Beacon Fen Energy Park – Development Consent Order

Application Reference: **EN010151**

Document: Deadline 8 – Closing Summary Statement (LCJM)

Author: Matthew Mountain, Director, L.C.J. Mountain Farms Ltd

PART OF  SLR

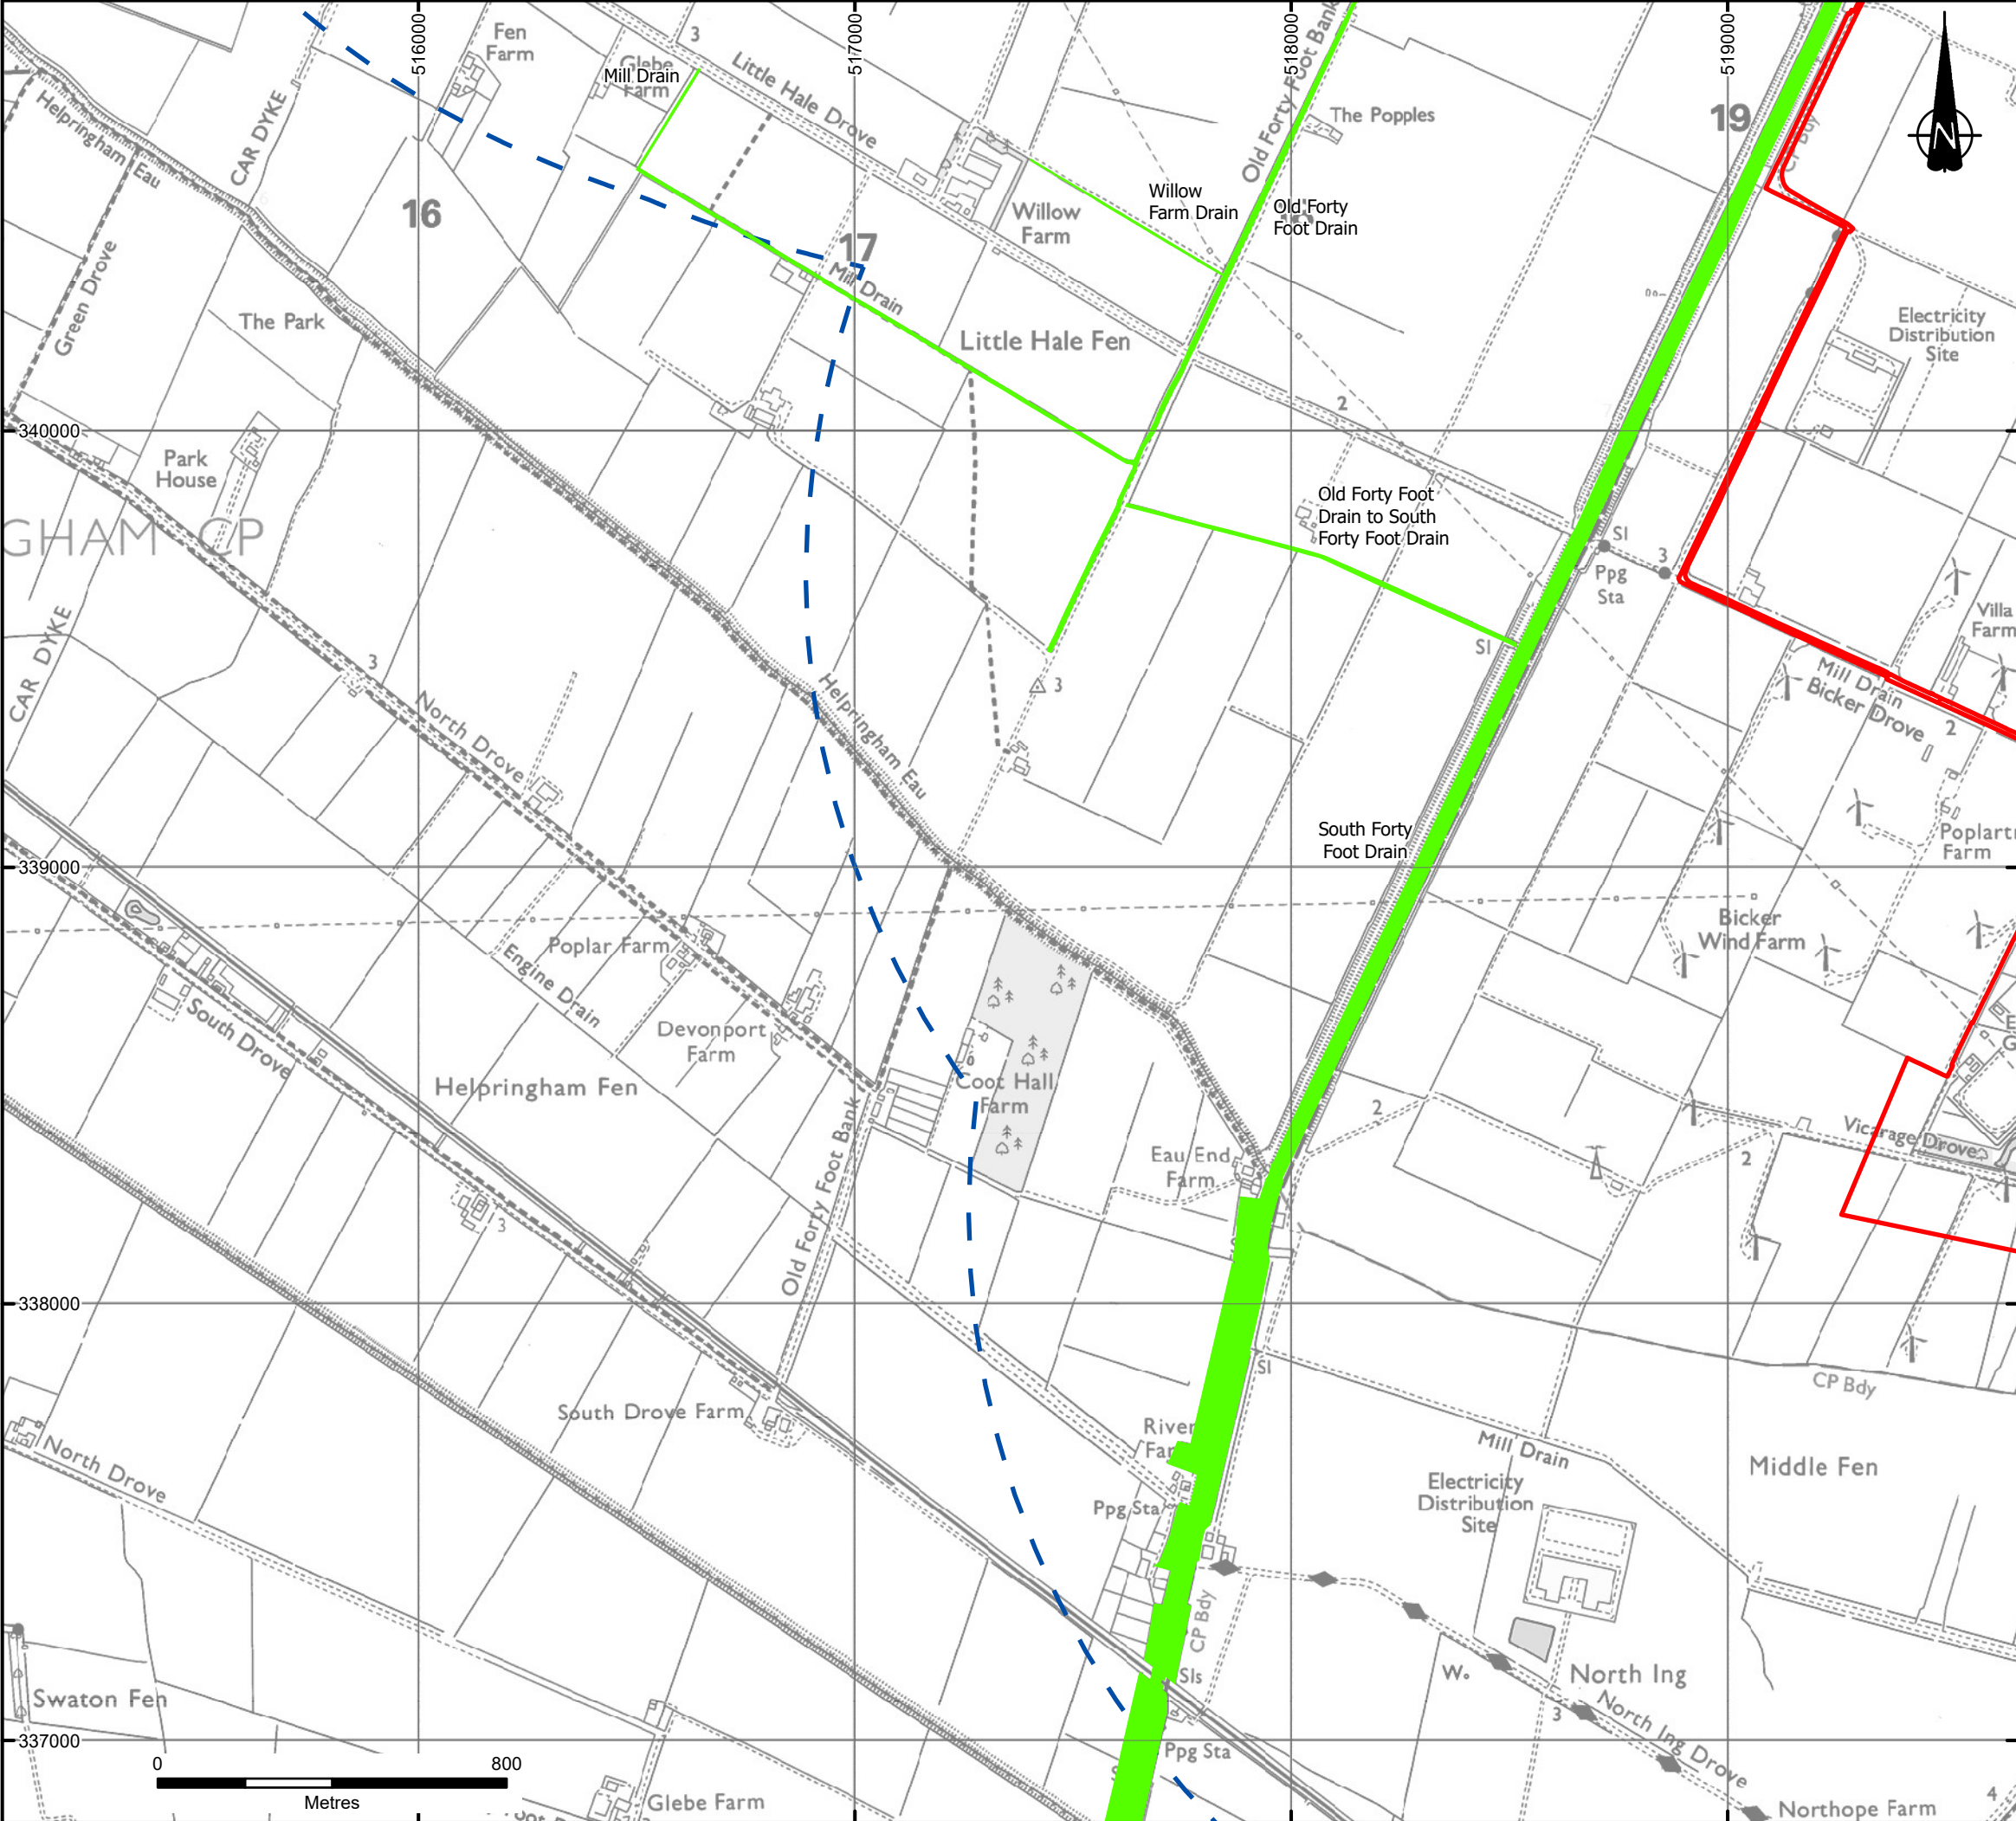
LCJM's case is that the Applicant treats LWS proximity/interaction as a discriminator against "alternatives" yet accepts substantial longitudinal interaction [1,650 metres] and "double occupation" adjacent to LWS 4722 on the chosen corridor, while simultaneously presenting temporary access as benign.

5.4a LCJM also records the decisive point for weight: the LCJM Hybrid alignment **avoids 1,650 metres occupation of LWS 4722 entirely** (i.e. it does not intersect that LWS and does not require longitudinal working alongside it). This matters because the Applicant’s own optioneering narrative treats proximity to “sensitive receptors including Local Wildlife Sites” as a discriminator against alternatives, yet the chosen corridor accepts prolonged, longitudinal interaction and indicative “double occupation” adjacent to LWS 4722. LCJM invites the ExA to record that this is not a decision-safe use of a constraint: **LWS sensitivity cannot be relied upon to rule out alternatives while being treated as acceptable-by-assumption on the selected corridor.** On that basis, LCJM invites the ExA to place reduced weight on the Applicant’s LWS-based comparative conclusions unless and until the Applicant provides an auditable, like-for-like construction footprint (including haul/access) and enforceable controls that prevent corridor creep and longitudinal working effects.

5.5 LCJM also records that the LCJM Hybrid alignment on the Little Hale Drove section has meaningful stand-off from nearby LWS features and does not intersect those LWS designations. LCJM has previously recorded on the Examination record that LWS 4489 (Mill Drain) lies approximately 274m south of the relevant section and LWS 4520 (Willow Farm Drain) lies approximately 177m north. LCJM maintains that it is not decision-safe to discount an alternative on the basis of LWS proximity while, for the chosen corridor, treating substantial longitudinal working / “double occupation” adjacent to an LWS receptor (LWS 4722) as acceptable by assumption. LCJM further notes the cumulative construction context at this location arising from the relatively recent Viking Link onshore works, which reinforces why LWS-related comparisons should be based on mapped, like-for-like construction footprints and duration assumptions rather than corridor-only screening.
